WEST SUSSEX COUNTY COUNCIL CONSULTATION

TO:	Arun District Council FAO: Michael Eastham
FROM:	Stephen Gee WSCC - Highways Authority
DATE:	16 November 2020
LOCATION:	Land west of Tye Lane Walberton
SUBJECT:	WA/68/20/OUT Outline application with all matters reserved, other than means of access, for the construction of up to 155 No. dwellings (30% affordable homes) & amendment to boundary of garden land to serve adjoining property. This application affects the character & appearance of the Walberton Village Conservation Area, may affect the setting of listed buildings & is a Departure from the Development Plan.
DATE OF SITE VISIT:	
RECOMMENDATION:	More Information
S106 CONTRIBUTION TOTAL:	n/a

The application is for upto 155 dwellings with all matters reserved except for access at Land West of Tye Lane, Walberton.

MOVEMENT STRATEGY PLAN

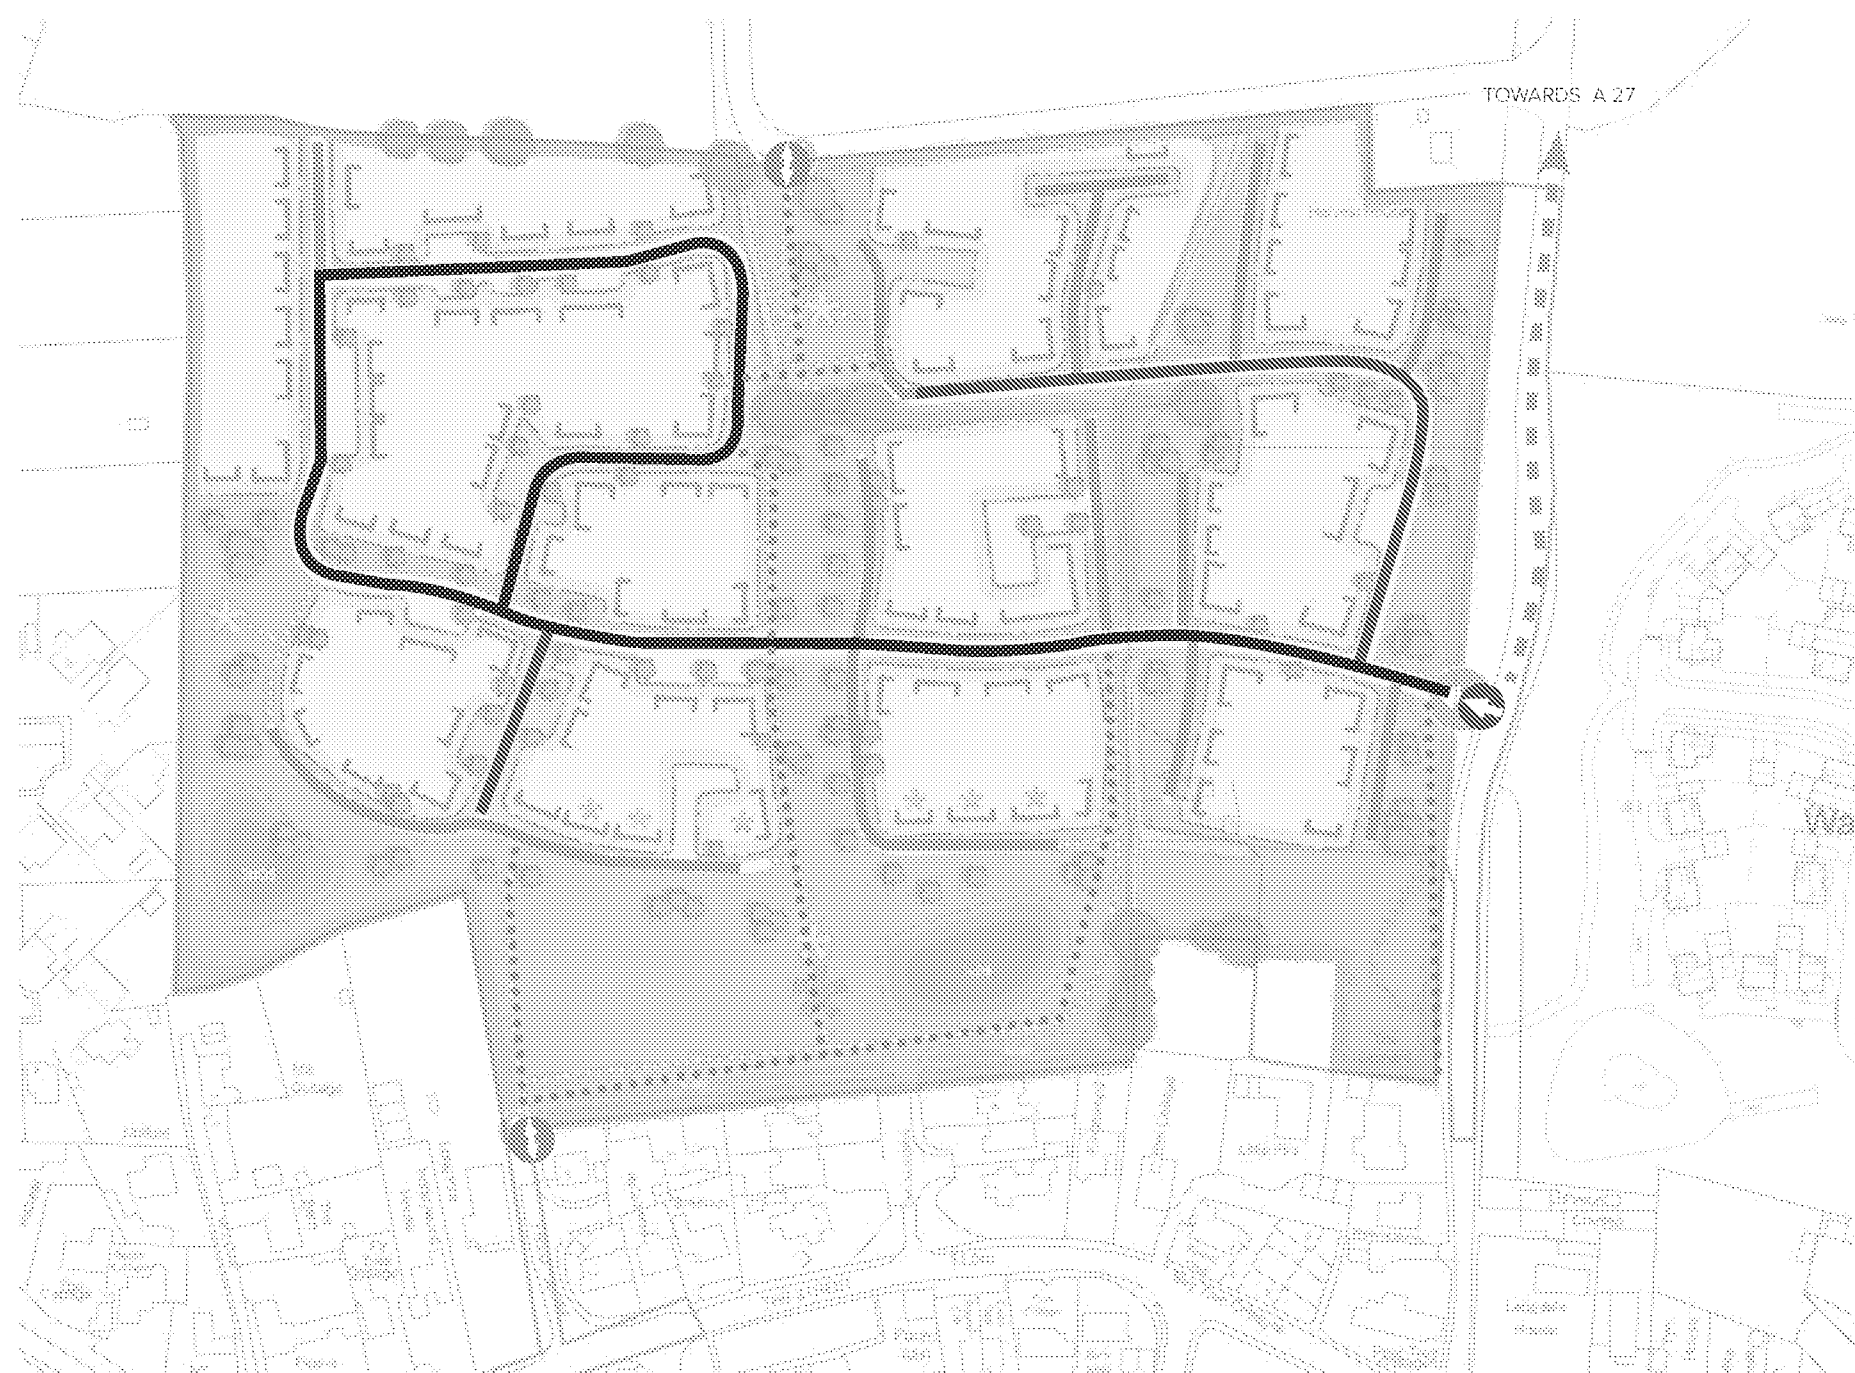
The concept masterplan details an internal ped/cycle route that links to the ped/cycle access of WA/44/17.

Whilst the report indicates that WA/44/17 provides a ped/cycle connection onto Tye Lane and as such pedestrians utilising Tye Lane as a shared surface, the level of pedestrian activity generated by the two sites onto Tye Lane is not felt to be comparable.

Land East of Tye Lane has a number of pedestrian connections with local facilities to the south of the development. Whereas the accessibility map shows the majority of local facilities such as the school being to the south east of the site and as such has the potential to increase pedestrian trips along Tye Lane. Additionally, this application would increase vehicle trips along this section of Tye Lane.

As such further details of future AADT and pedestrian flows and the identification of any pedestrian improvements should be provided.

A 2nd ped access is provided to the south west of the site via Field. The applicant should confirm sufficient access rights exist to provide this link.

Whilst an issue for a future reserve matters application, the internal network would benefit from the creation of an internal loop to reduce the potential of a point of blockage within the development.

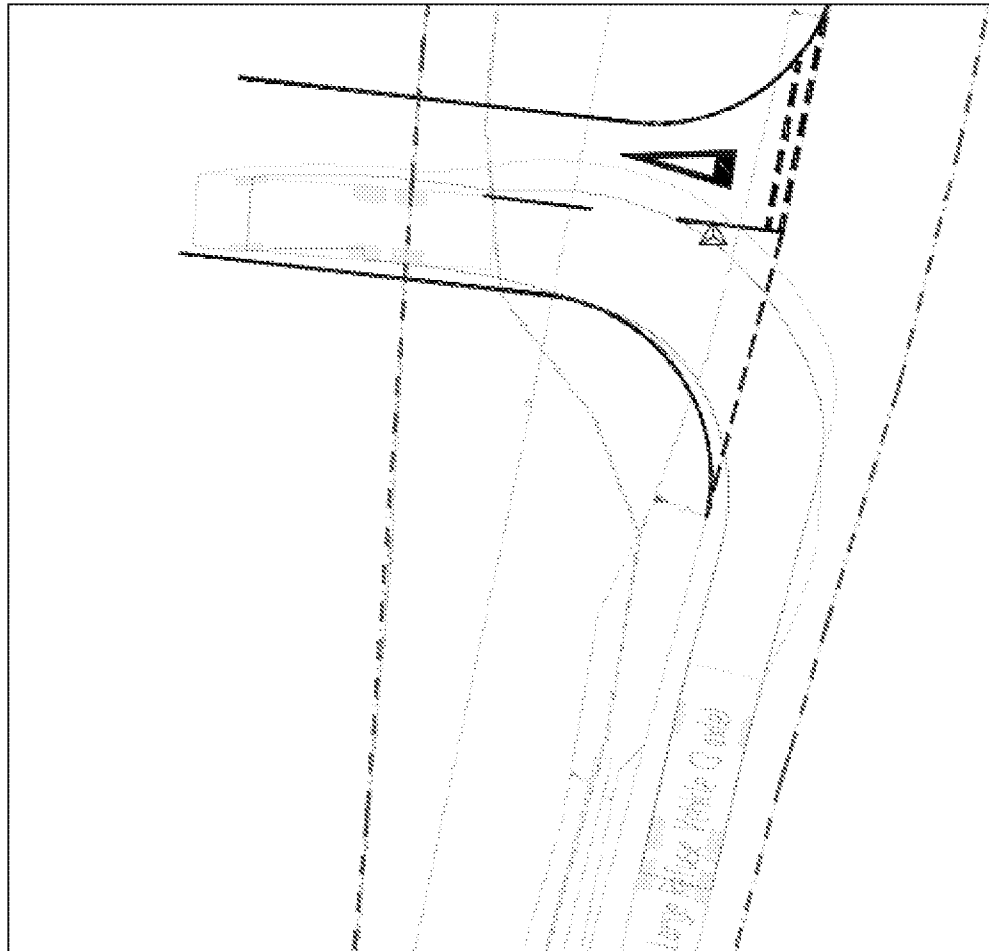
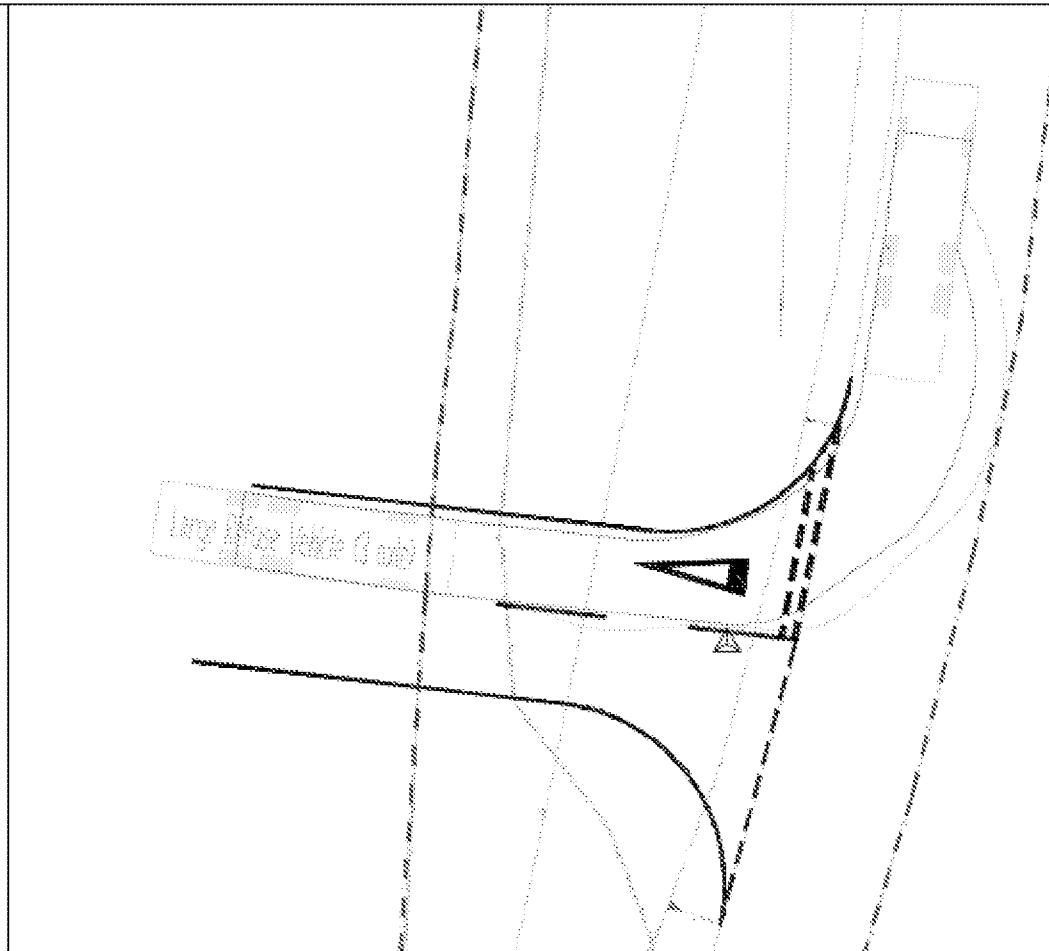
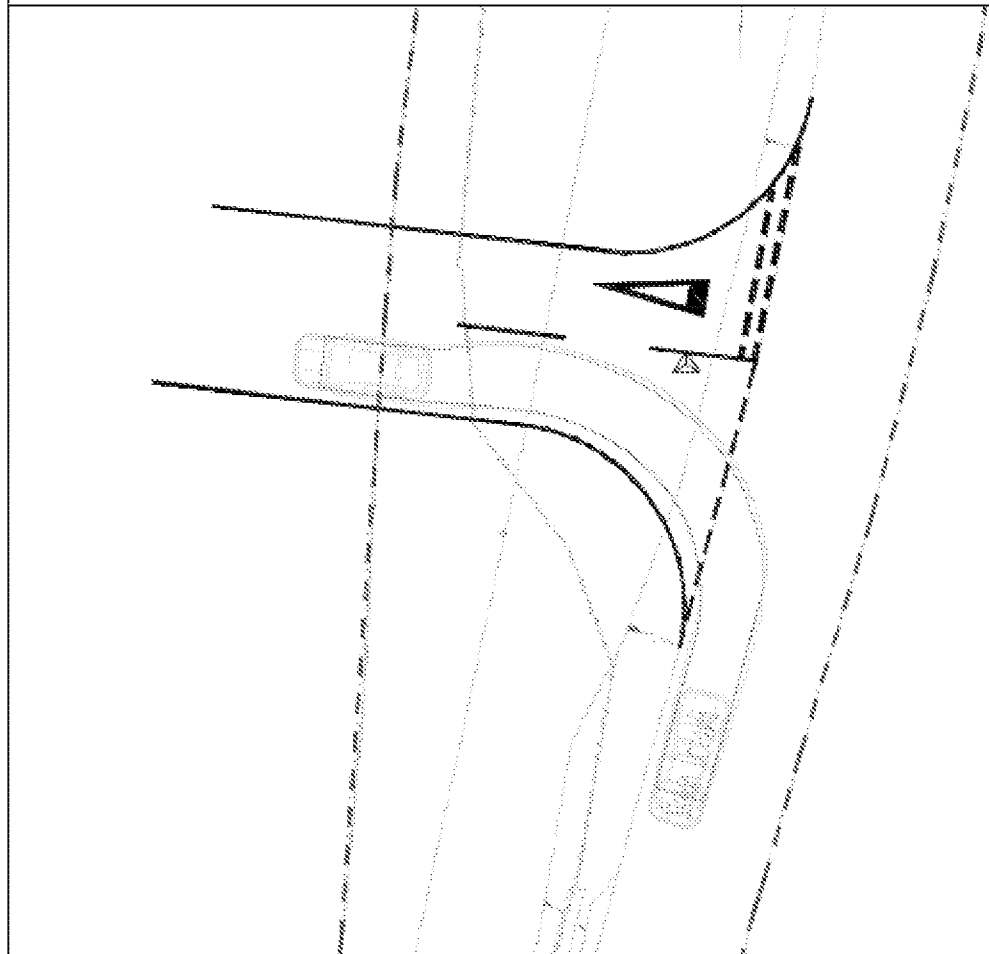
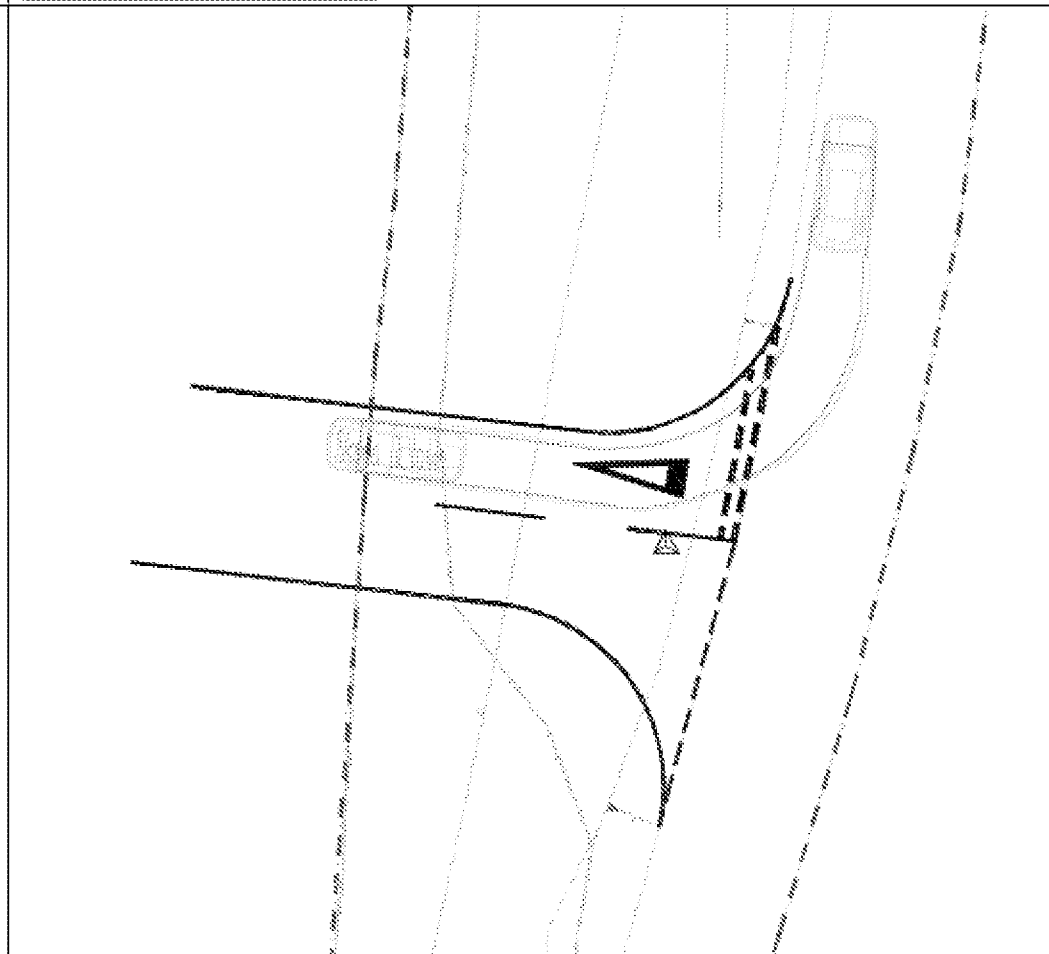
It is proposed to provide a simple priority junction 6m in width and with a 6m corner radii. A stage 1 RSA has been undertaken which highlighted X issues all of which are agreed by the designer. A word copy of the Designers Response should be provided to allow highway authority commentary on the responses. Visibility splays of 4.5m x 120m can be provided in line with DMRB requirements.
